**Re: 4190 Hancock Expressway PPR-2348 – Site Development Plan Comment Response Letter
MVE Project No. 61179**

The submittal documents for the 4190 Hancock Expressway Site Development Plan application have been revised and corrected per the comments received by the various reviewing agencies. Most of the revisions are provided in the submittal documents without further discussion. However, some of the comment responses require further explanations which follow in the notes below.

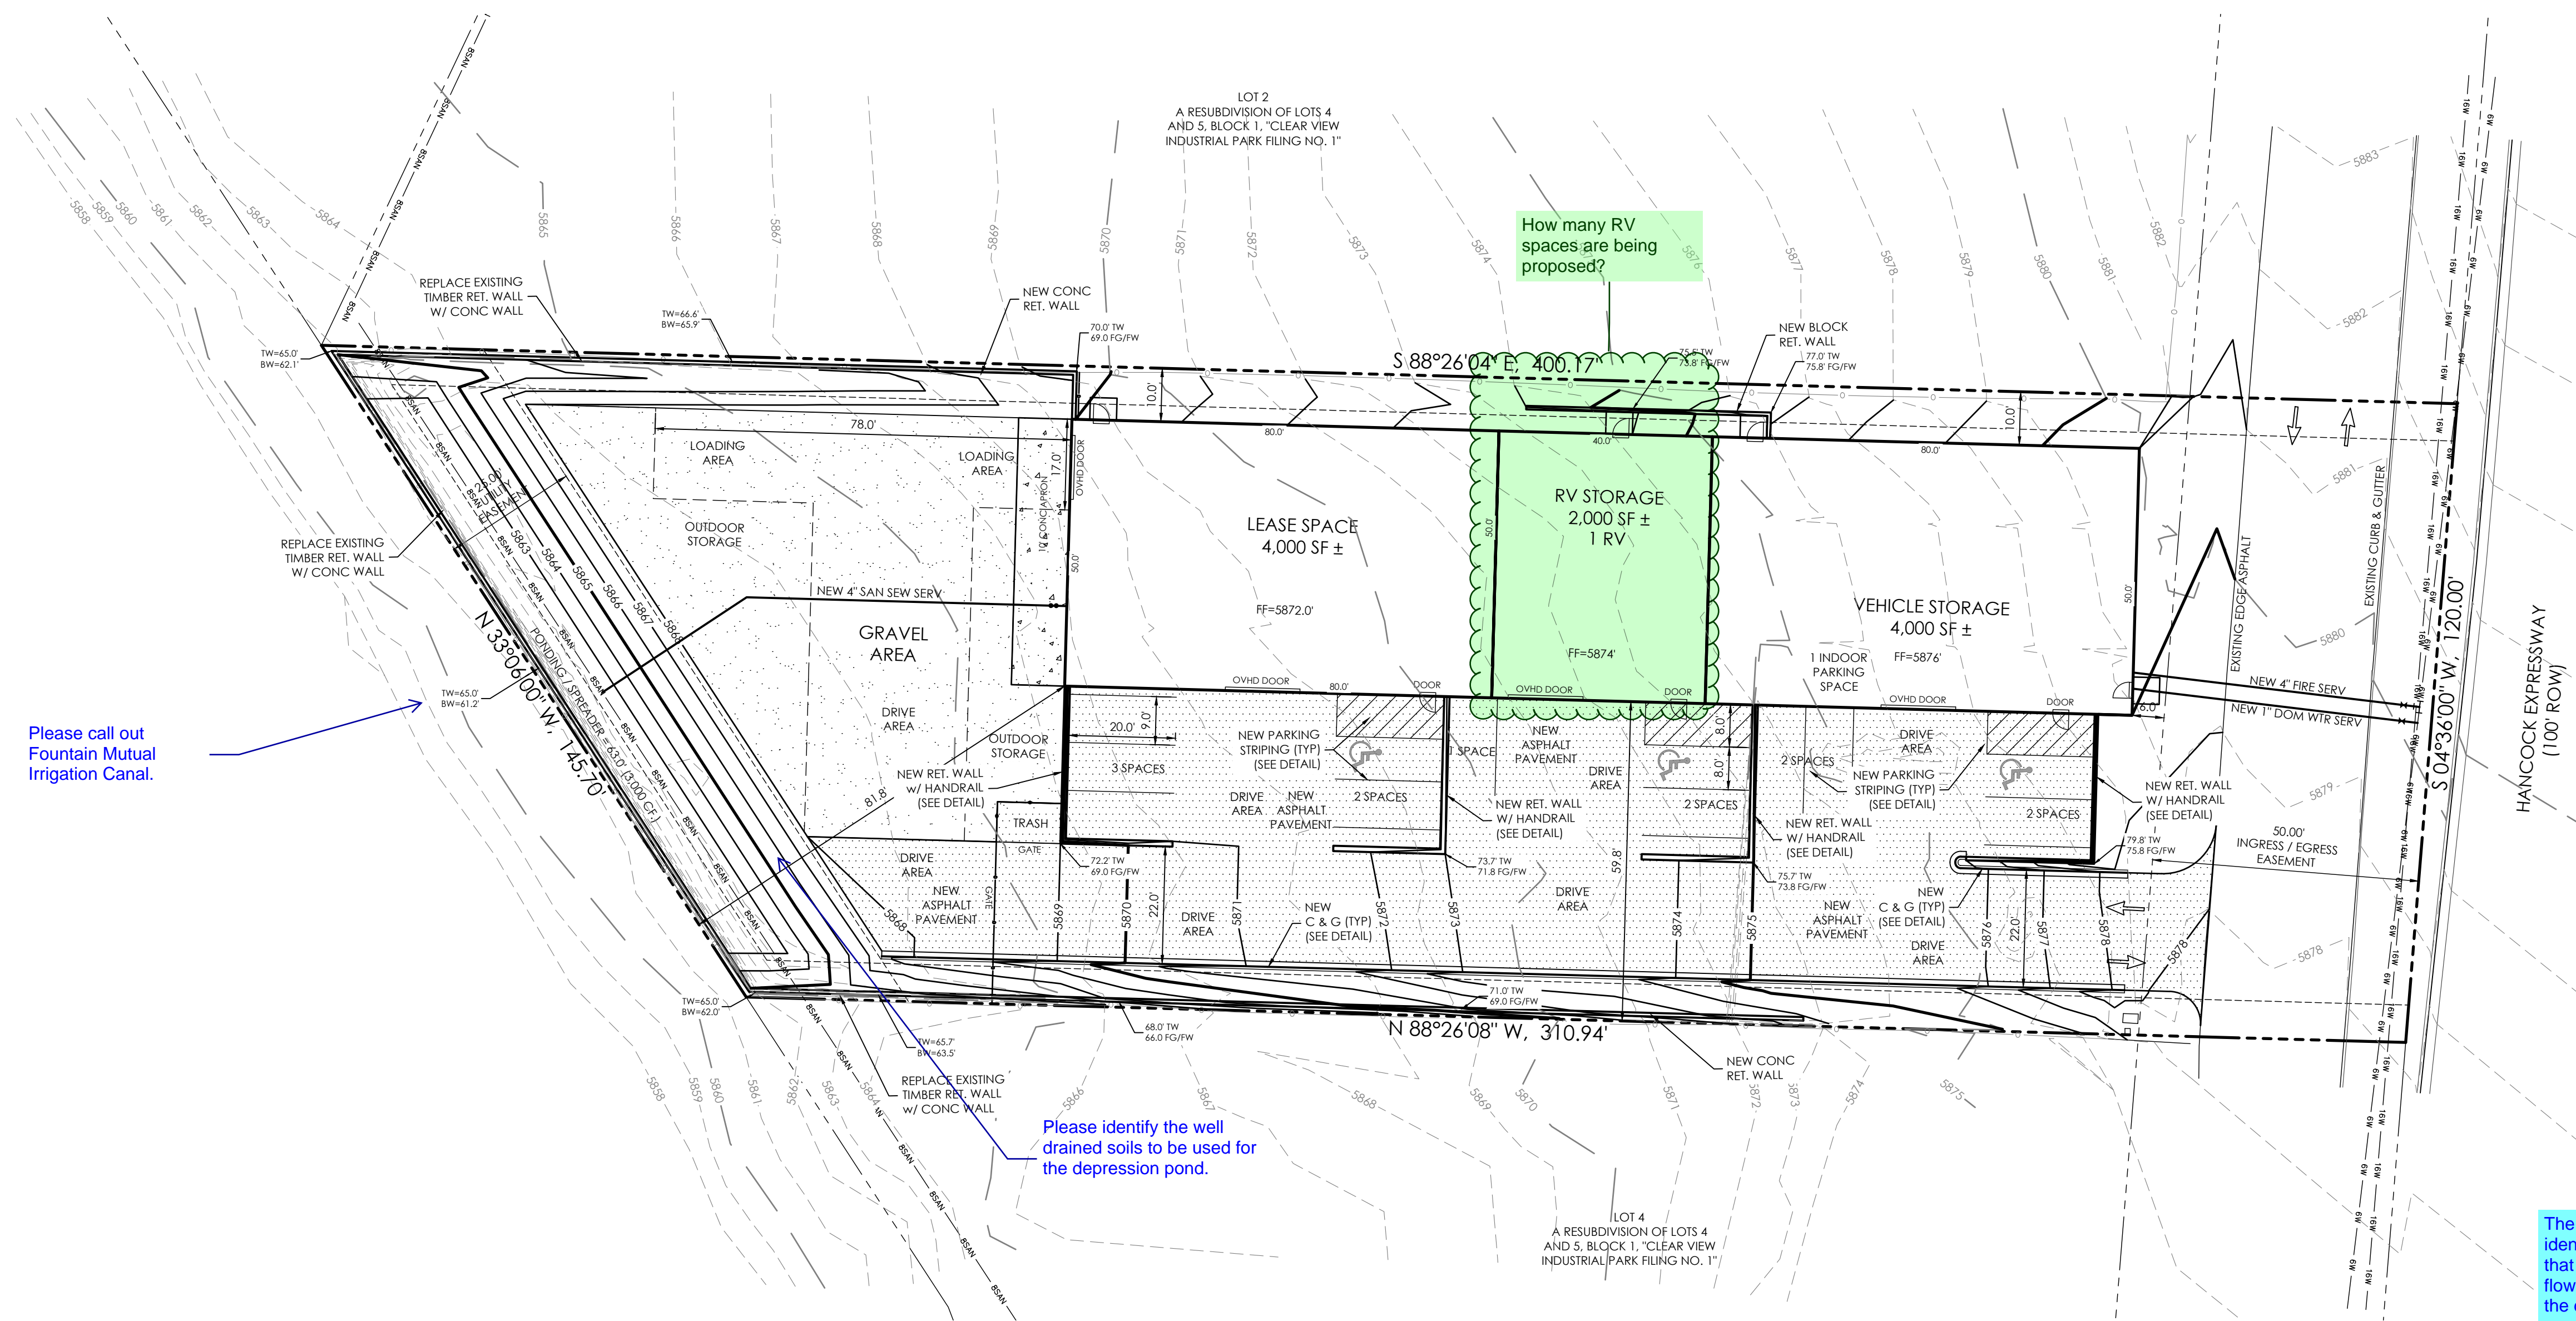
PCD Eng Comment: “Please identify the well drained soils to be used for the depression pond.”

MVE Response: Any potential infiltration into the soil is not considered in the release rate of the ponding area. All flows are considered to exit using the wall orifices. No information about the soil permeability or soil infiltration rates is available or needed for this project. References to infiltration being used was removed from the drainage report. No note or callout was added the the Site Plan.
